Re: Planning Application 3/2023/0058 at 5 Whalley Road, Read, BB12 7PB

SIDE ELEVATION [No.3] - 1:100 at A3

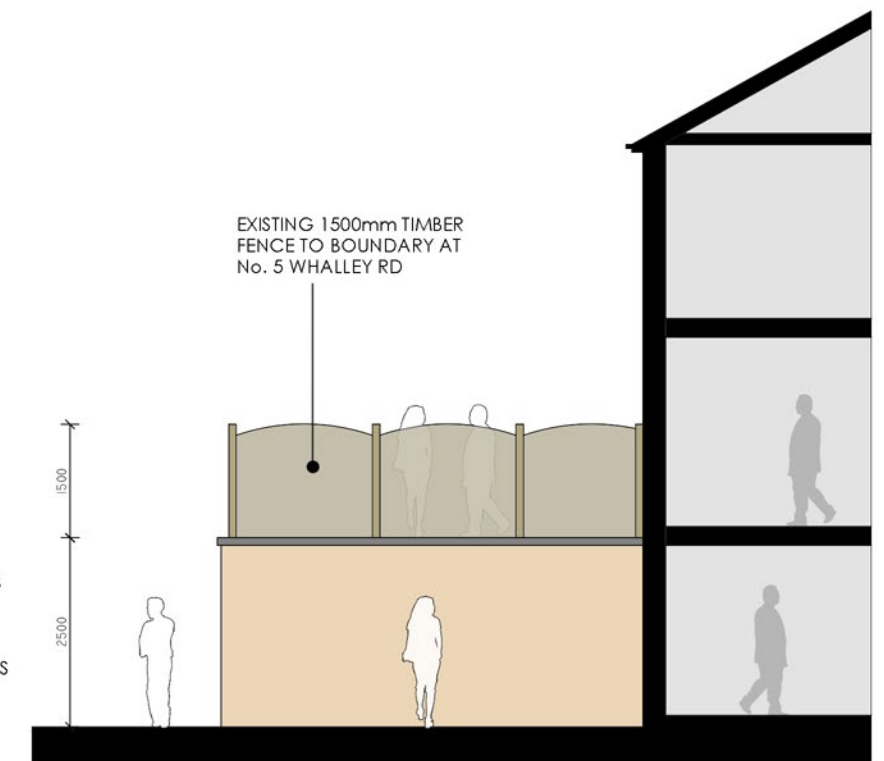
A recent planning application (3/2023/0058) has been made which seeks to keep the 1500mm tall fence. In the original planning application the fence was to be 4 foot (approx 1220mm) tall. This was refused as The proposal is considered to be in conflict with policies DMG1 and DMH5 of the Ribble Valley Core Strategy in as much that the proposed fence, by virtue of its design and spatial layout, would have an overhearing impact leading to an unacceptable loss of natural light and outlook for the [REDACTED] residing at the property known as [REDACTED]. The Parish Council does not believe that a taller fence would be less obstructive in this respect.

[REDACTED] has advised that the new plans are misleading and seeks for the matter to be resolved as soon as possible after almost a year of having no light [REDACTED]. The Parish Council supports him in this regard.

SUN PATH PLAN - 1:500 at A3

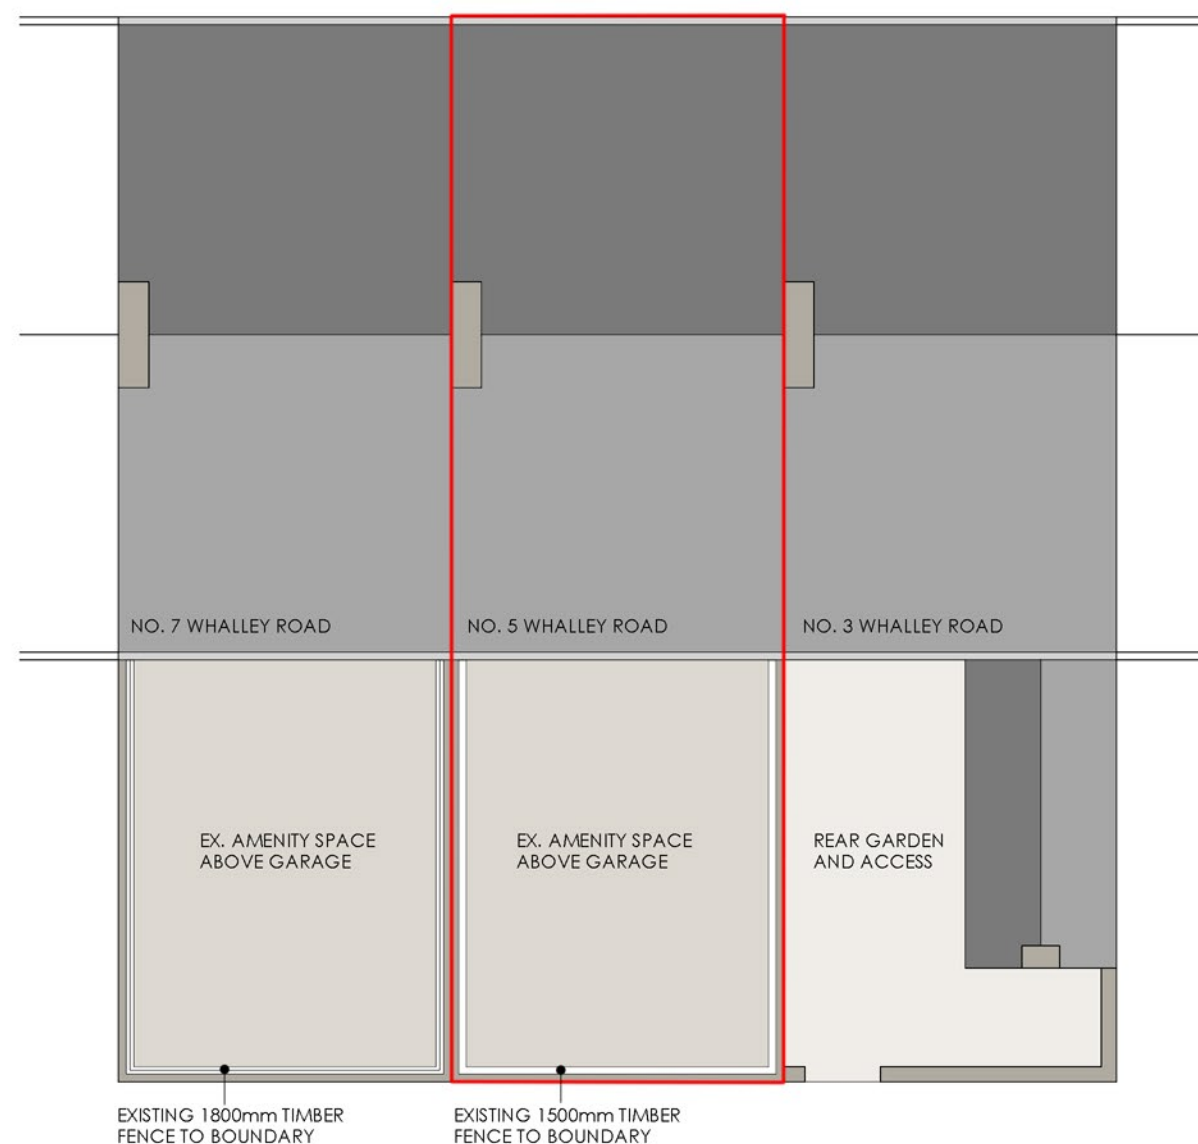
The resident advised the Parish Council that the glass balustrade was never erected and instead in May 2022 a solid wooden fence was put in place similar to the original rejected plans. Ribble Valley Planning department were contacted at the time and came back to advise [REDACTED] that the property was under new ownership and that the new owner was not aware of the planning condition. Since this time [REDACTED] advised he has contacted the planning department on several occasions as the fence remains in situ and is blocking light to [REDACTED] however he advises no actions have been taken.
